30 May 2013

Re: Exhibition of Environmental Assessment for Concept Plan Approval – Mixed Use Subdivision, West Culburra (MP09\_0088)

In response to the 'Utilities Investigation Report' (Ref: 25405 November 2012 Rev: 00) and the Concept Plan (Drawing Ref. no. 25405-30, Sheet 1 of 1, Revision O4 by allen, price & associates) showing site constraints over various parts of the proposed subdivision at West Culburra, Endeavour Energy's comments on the proposed '0.9Ha Zone Electrical Substation' site are as follows:

25405-37

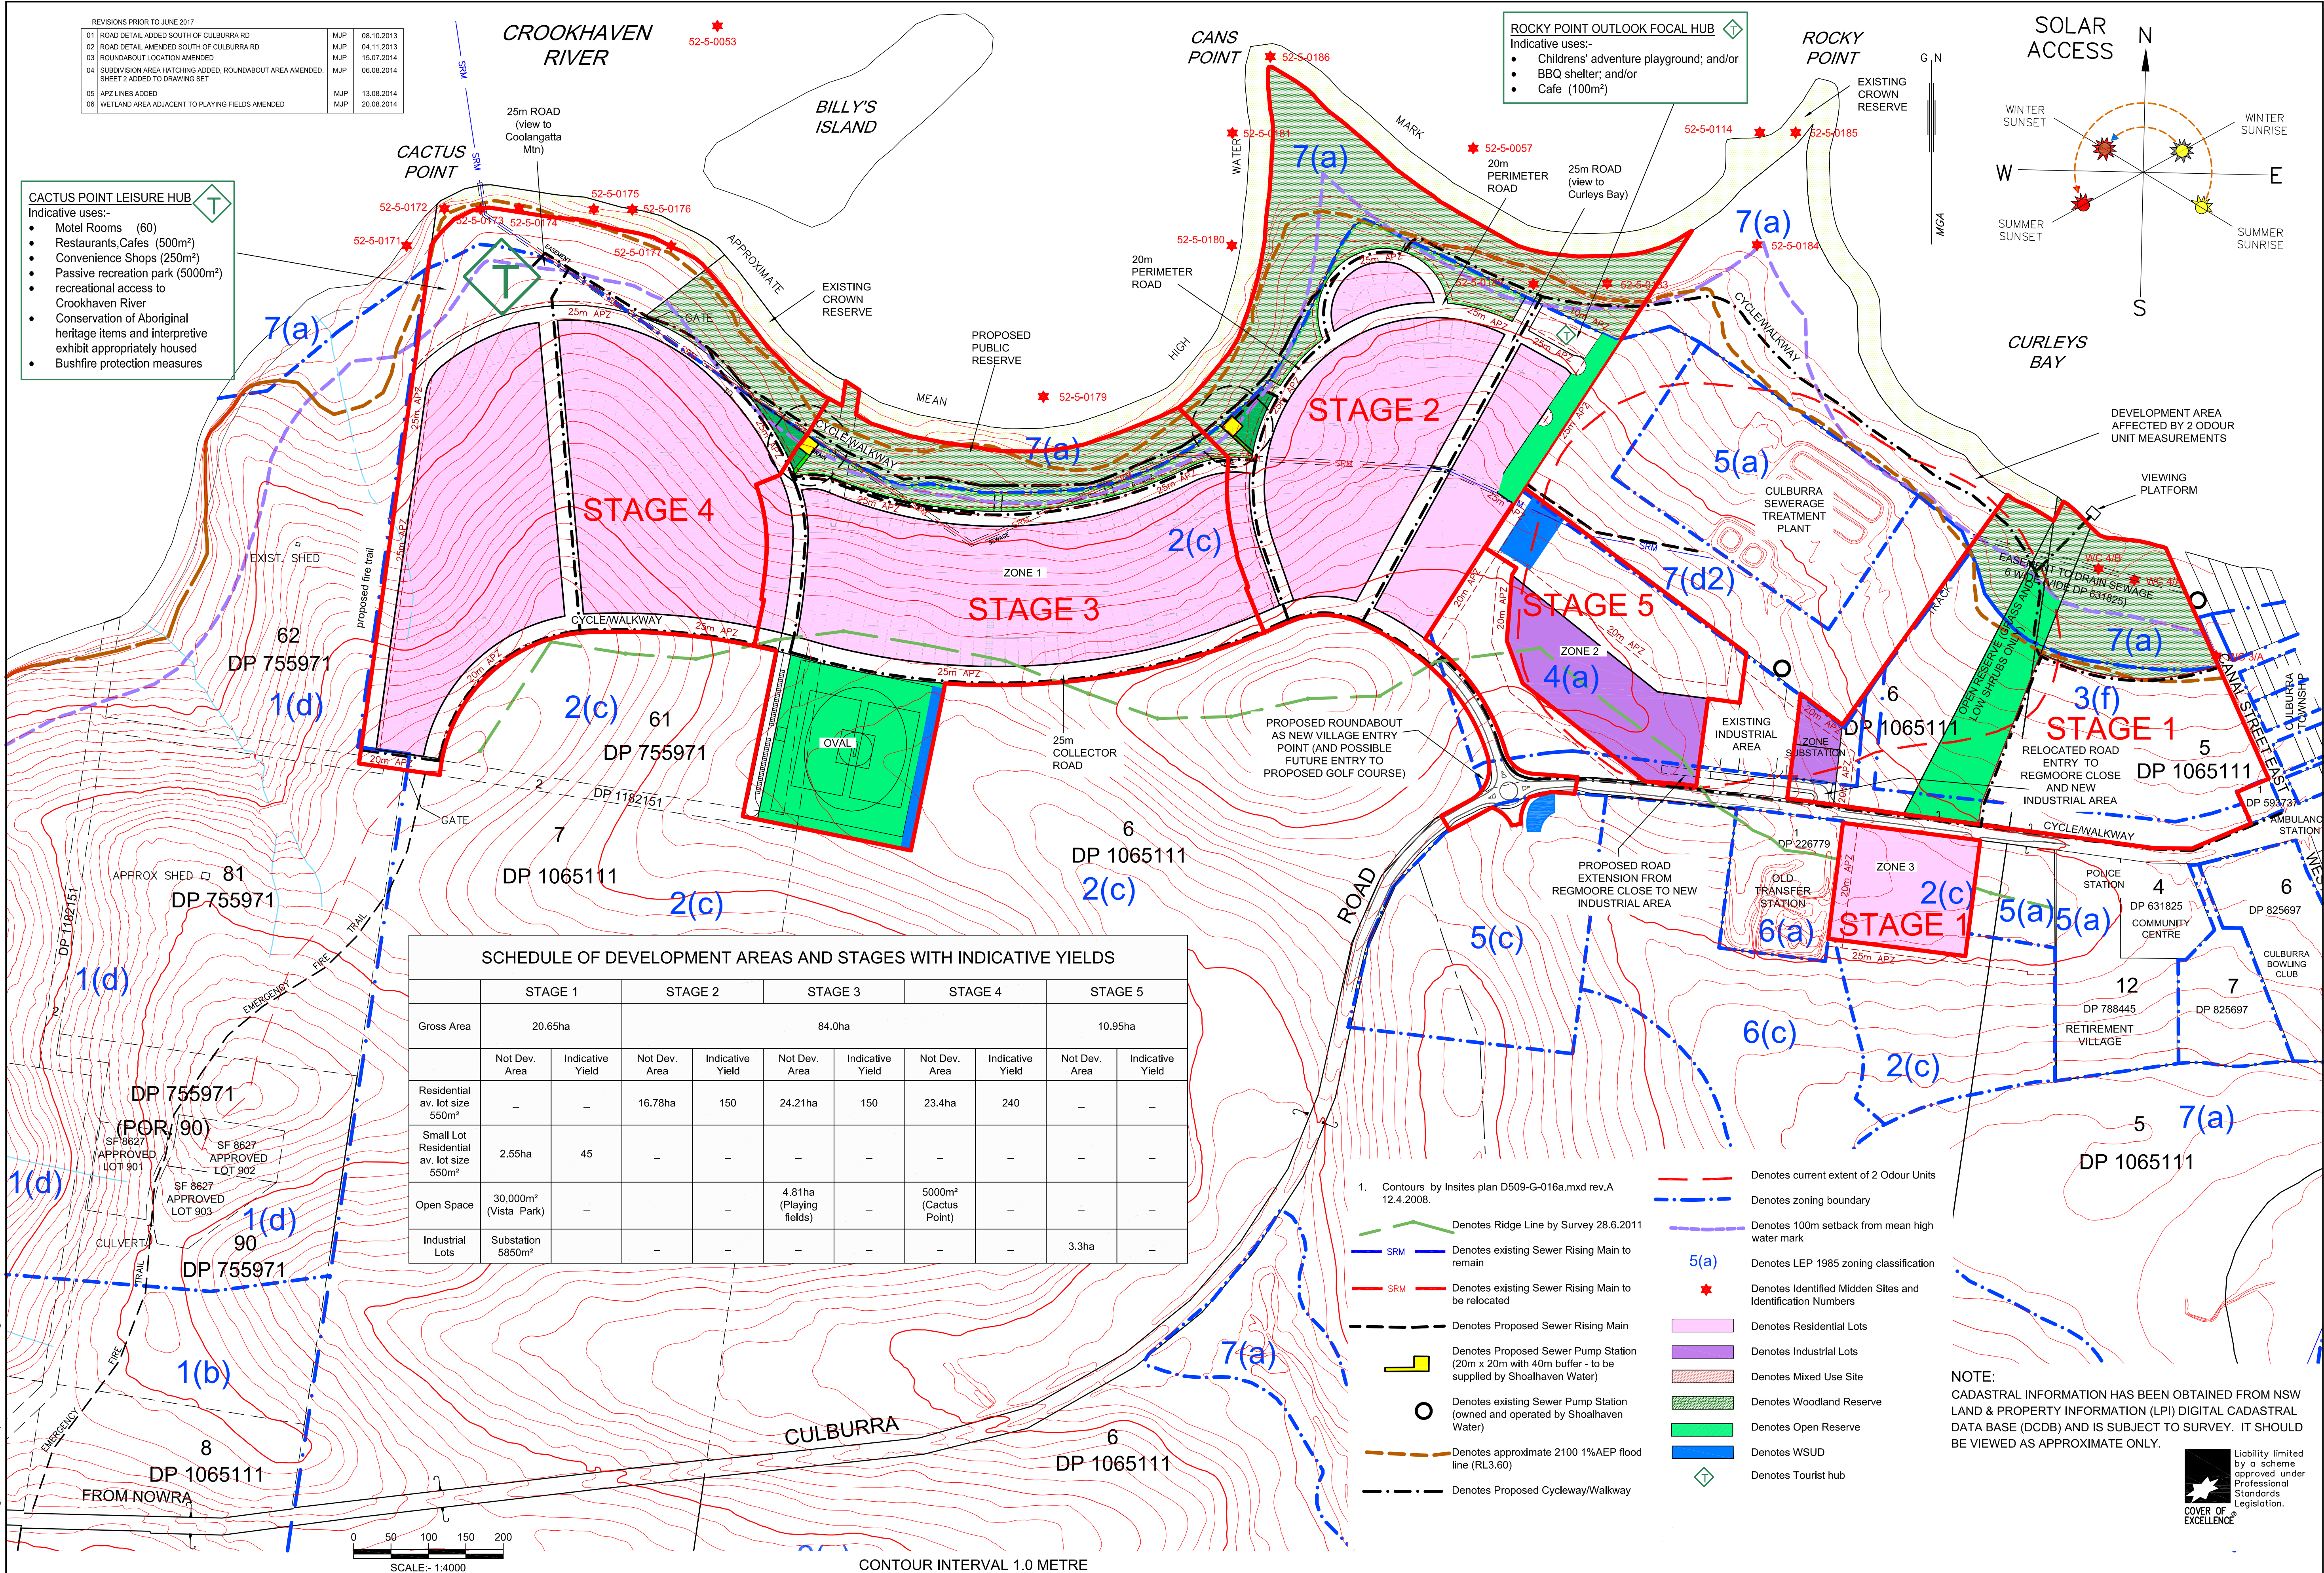
- The proposed 0.9Ha Zone Electrical Substation appears to be located via an access road off Culburra Rd opposite the 'Old Transfer Station' and set back approximately 200m north from Culburra Road.

- Endeavour Energy's preference would be for the proposed cleared zone substation site to be located adjacent to the frontage of Culburra Road by relocating the site a couple hundred metres south. The minimum Zone Substation site size is a rectangular 40m (wide) x 60m (deep) flat and cleared parcel of land.

- It is believed, that the visual amenity of the substation can be satisfactorily addressed by leaving a small strip of existing vegetation/trees between Culburra Road and the cleared Zone Substation site.

- The advantages to the developer and Endeavour Energy would be cost savings in shorter incoming and outgoing feeder circuits, the development of a shorter heavy duty access road and electrical earthing compatibility would be better if the zone substation is located as far as possible from the existing Sewerage Treatment Plant.
